Application for Planning Permission for Works or Extension to a Dwelling

Development: Erection of single storey side/rear extension, hip to gable roof extension including external alterations, following the demolition of existing rear extension and conservatory and part demolition of detached garage

Location: 12 Old Manor Road Rustington BN16 3QU

02 EXISTING Block Plan
1:500

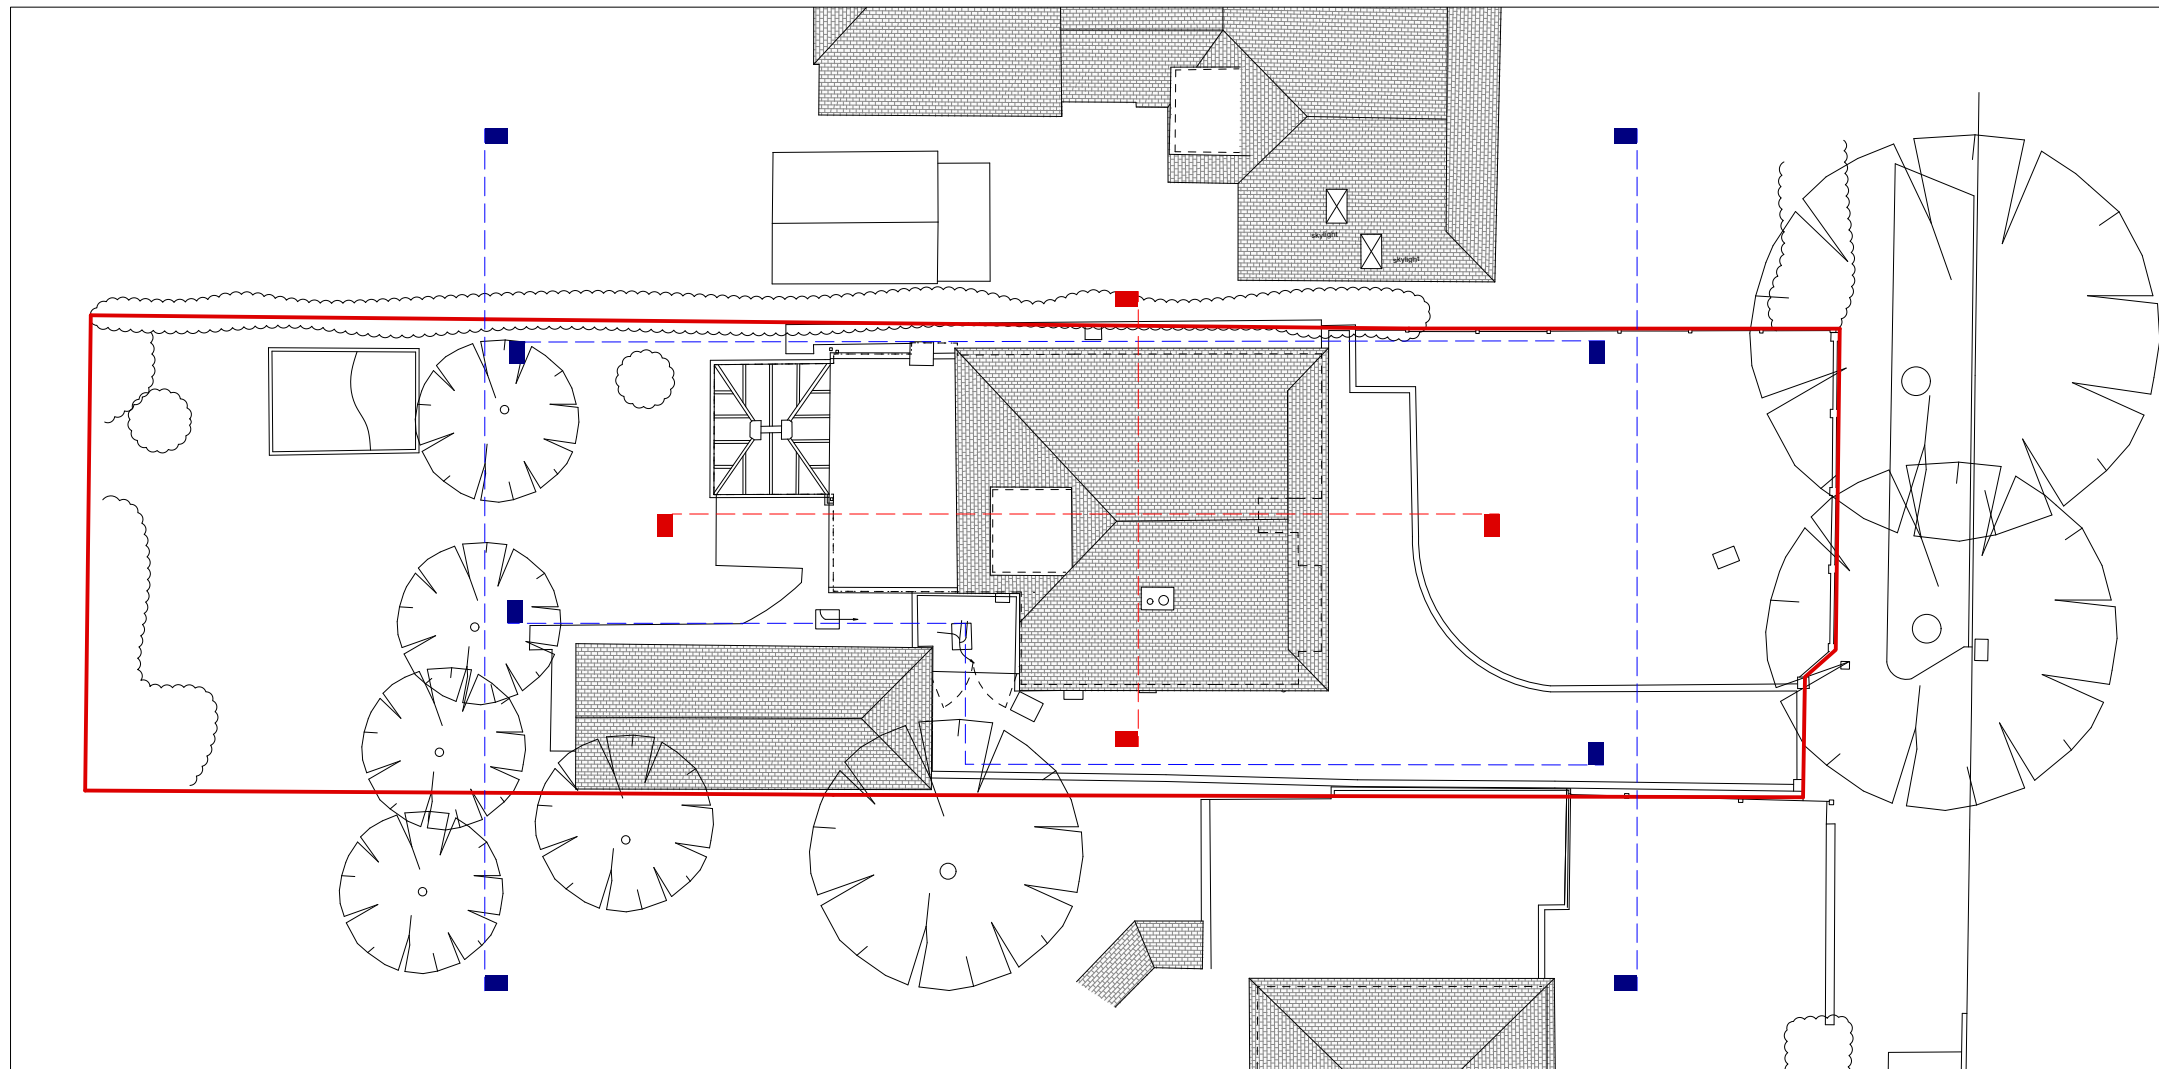
You are required to have dimensions from the proposed extension(s) to all site boundaries. Please amend.

01 PROPOSED South Elevation
1:100

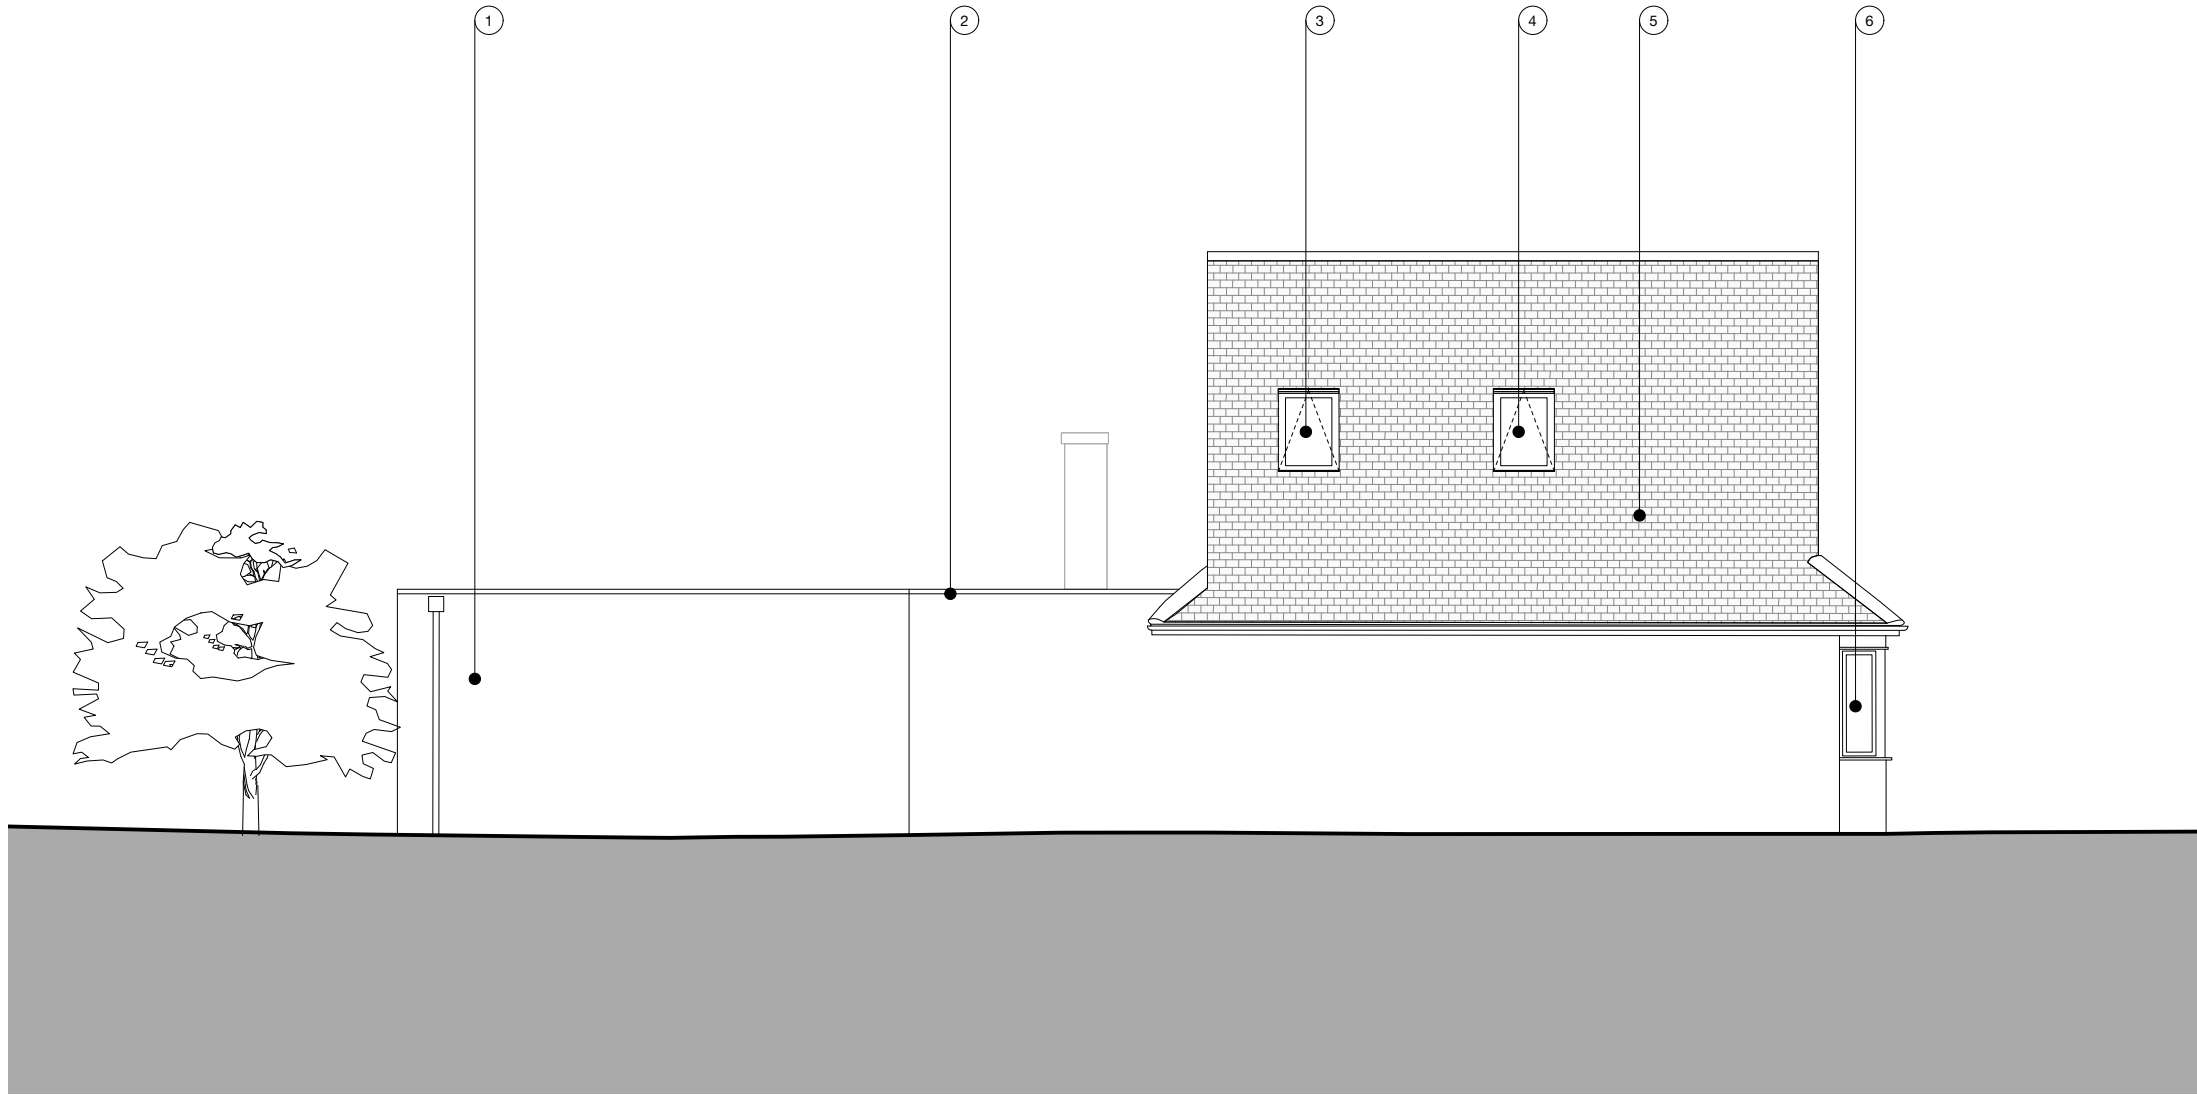
The scale bar on the proposed south elevation does not measure to scale. Please review and amend accordingly.
